**BLAZE-INN SADDLES
FORMERLY THE PHEASANT PLUCKERS INN
BISHOPS END
STREET THROUGH BURDROP
SIBFORD GOWER
OXFORDSHIRE
OX15 5RQ**

APPEAL: 21/04166/F

**BLAZE-INN SADDLES:
PLANNING APPLICATION: 21/04166/F**

**PAPER SIZE : A4
SCALE 1: 100
REVISED ELEVATIONS**

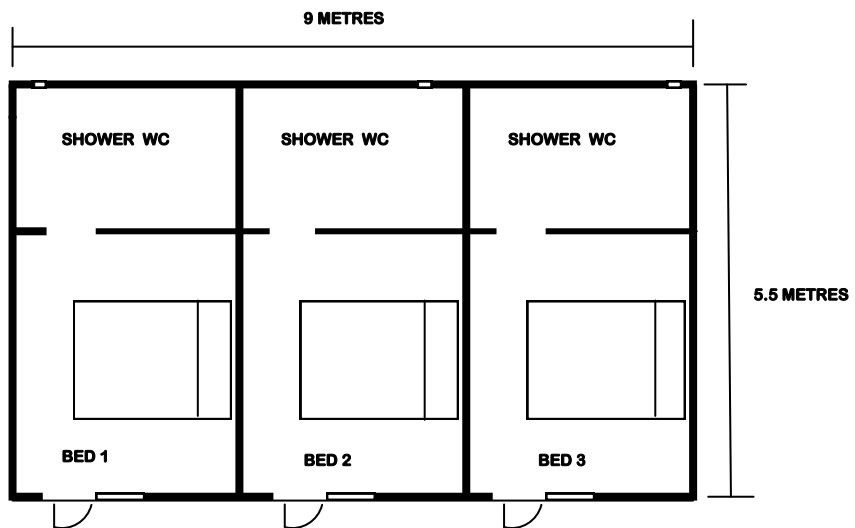
There are also concerns with the design of the building which is overly domestic and does not respect the surrounding vernacular buildings.

(p5). Proposed building: There are particular concerns, namely: Location: Given the proximity of the neighbouring Grade 2 barn, it appears likely that any building in this location may have a negative impact on the structural integrity of the barn. Size and Scale ? the proposed building has a significantly larger footprint and height, comprising 3 bedrooms, together with kitchen, utility & boots, bathroom and sitting room. This would appear to constitute an entirely new building, identified by the applicant as the Proposed Cottage? (p4), rather than an Amendment (p5). Design ? the proposed design does not appropriately reflect the photographic evidence provided to support the relocation and is not complementary to this location, thereby having a negative impact on the identified street scene in this sensitive conservation area Materials ? the photographic evidence clearly identifies local stone and thatch, which has been retained for the existing neighbouring barn. A similar use of materials would complement the adjacent Grade 2 listed building, generating a positive impact on the street scene in this sensitive conservation area. No specific details are included for doors, windows, rainwater goods Conditions: The scope and detail identified in the APP Schedule of Conditions (p5) continue to be appropriate and relevant for any building in this location

I have previously sent emails offering both yourself and the Conservation Officer an opportunity to consider and request any design and materials changes that you might find acceptable and that offer still stands.

If the Case Officer so wishes, we are prepared to change the proposed roof tiles of Welsh Slate to Cotswold Heritage Roof tiles and match the recent Additions at Barn Close. The footprint of the proposed new building is only 10% larger and the ridge height is 0.8 metres higher, these changes are not significant, they are minor.
